SBR Racing Rezone, Minor Sub and Special Use, P-17-002, MS-17-003, and AL-17-020

Please accept the following comments from El Paso County Public Health for the project referenced above:

Mike McCarthy, R.E.H.S.
El Paso County Public Health
719.575.8602
mikemccarthy@elpasoco.com
27Oct2017 Updated: 13Nov2017

SBR MOTOR SPORTS FINAL PLAT

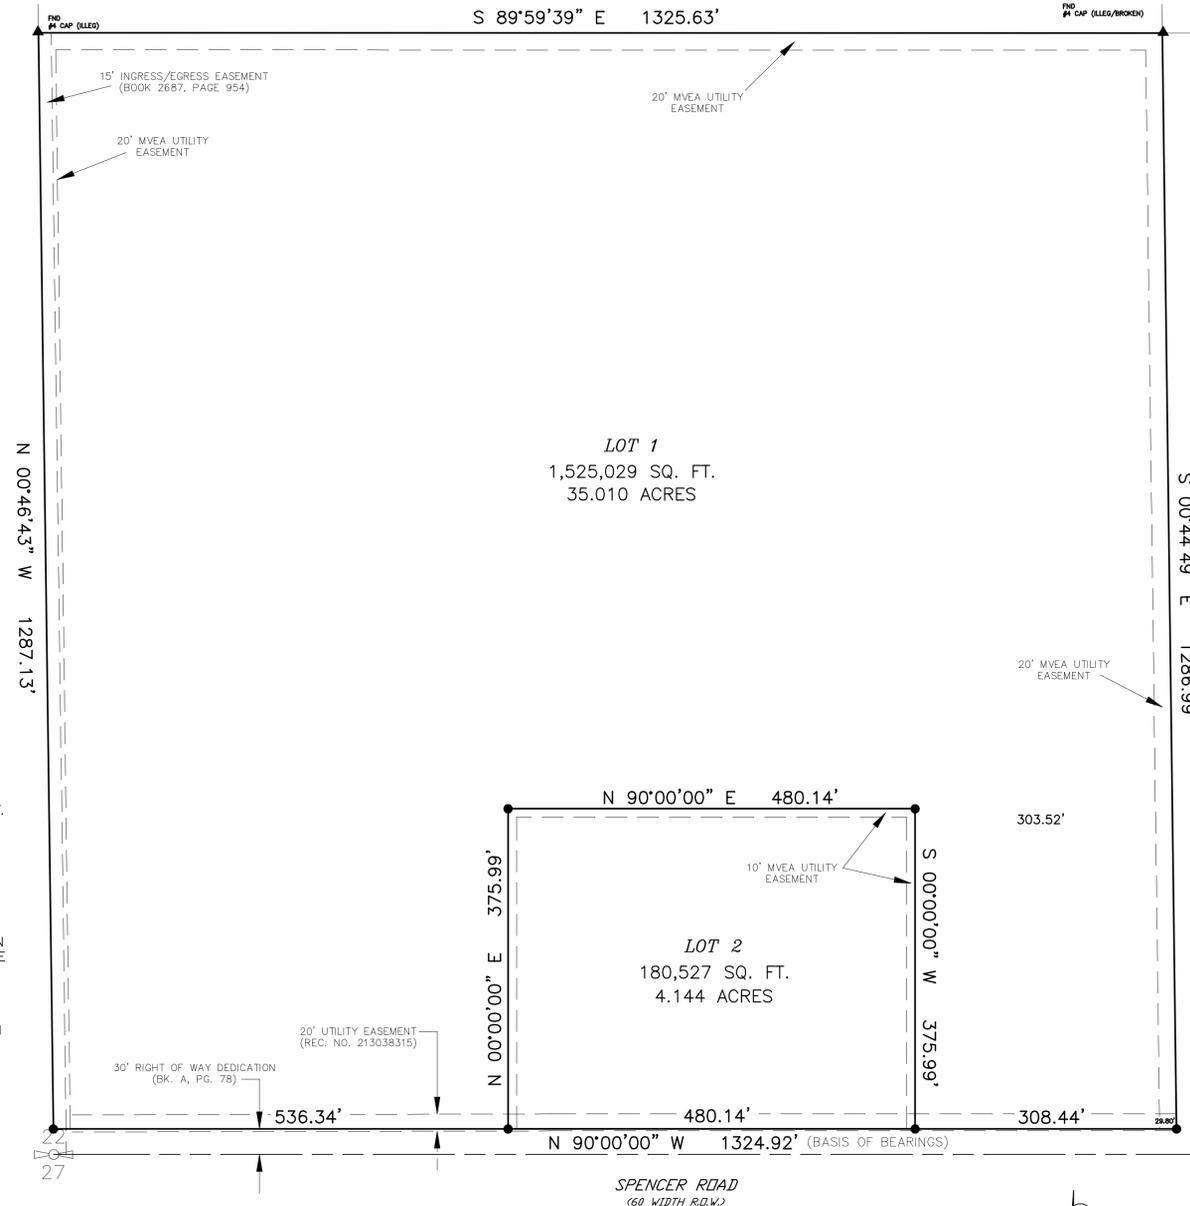
- **13Nov2017, Updated Comment:** Prior to scheduling this project for a hearing the information requested in the bullet below must be submitted to El Paso County Public Health. The existing OWTS on the proposed 5 acre lot must be entirely on the same lot, and there must be sufficient area provided for replacement of the soil treatment area should it be required.

- Wastewater service for the existing house is provided by an onsite wastewater treatment system (OWTS) that El Paso County Public Health does not have a record; therefore, the size and location of the system components are unknown. These components must be located and must all be inside the property lines of the proposed 5 acre lot and meet the current OWTS Regulations installation setbacks. There must be sufficient area dedicated on the proposed lot for a secondary soil treatment area if the existing soil treatment area were to require repair/replacement.

- Water service for the existing house on the proposed 5 acre lot is a private individual well. The well must be 100' minimum from the closest part of the soil treatment area, and 50'+ from the septic tank.
